Office of
Environment
& Heritage

WestConnex New M5 (SSI 6788) - Amended Submission

Attachment 1: The proposed WestConnex New M5 (SSI 6788) - Office of Environment and Heritage comments – 15 February 2016

Figure 10: Green and Golden Bell Frog species polygon

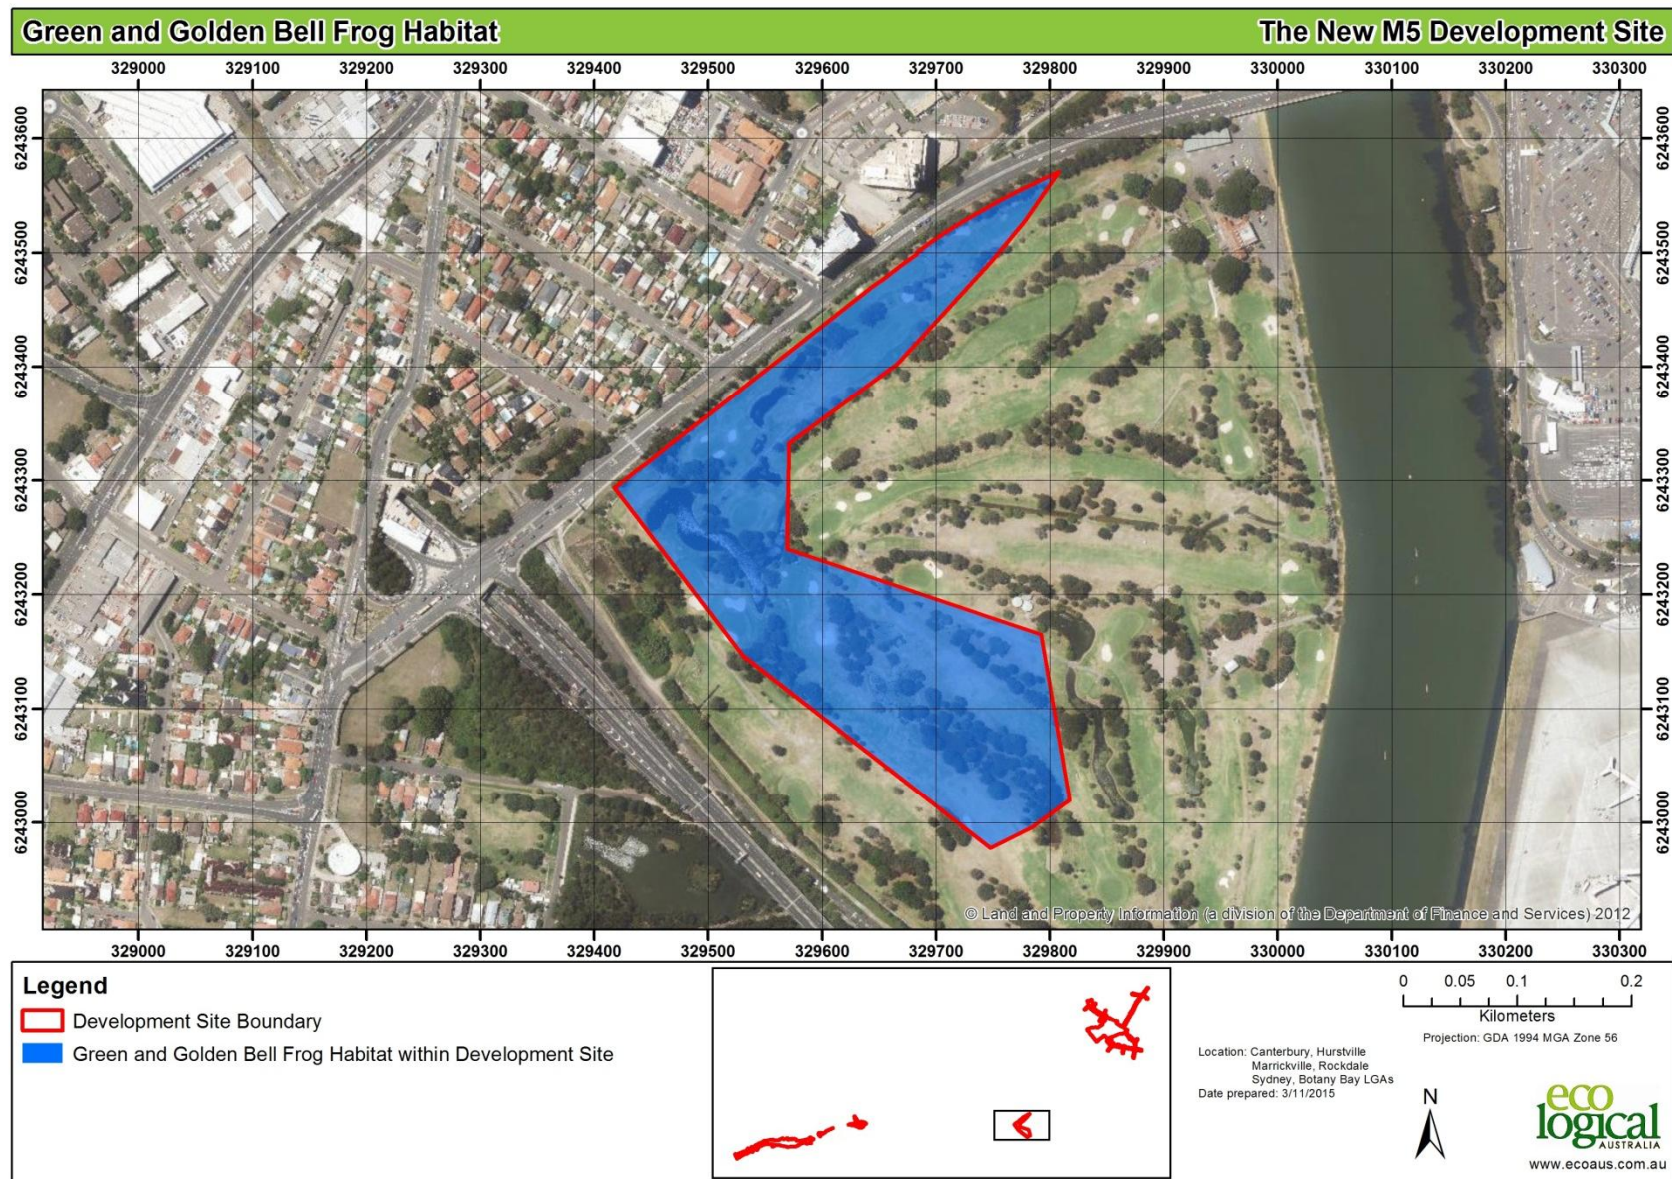
Significantly impacted EPBC-listed Threatened Species	Brief statement of the nature and extent of impact
Green and Golden Bell Frog	<p>Analysis of direct and indirect impacts in Table 16 of BAR:</p> <ul style="list-style-type: none"> • 7.82 ha of foraging, sheltering and dispersal habitat, small number of intermittent breeding ponds (artificial) temporarily unavailable during construction. • Smaller, unspecified, area (including one pond used rarely for breeding) permanently lost due to construction of operational facilities. • Potential for direct loss of individual GGBF during construction. • Potential for water spillage to transfer Chytrid fungus to existing breeding ponds during construction. • Potential for indirect impacts through noise, dust, light and vibration during construction.

Species	Area	Credits required
Green and Golden Bell Frog	7.82 ha	203

The analysis of indirect impacts is thorough and complete. Measures proposed to avoid and minimise indirect impacts are the most appropriate available. There is a very low risk that indirect impacts could result in the loss of the breeding population of GGBF at Marsh Street during construction, but the consequences of such an outcome are high which is why it is proposed to establish an ex-situ population. It may be appropriate to condition the approval to require additional offsets should the worst case scenario arise and the population on site be lost.
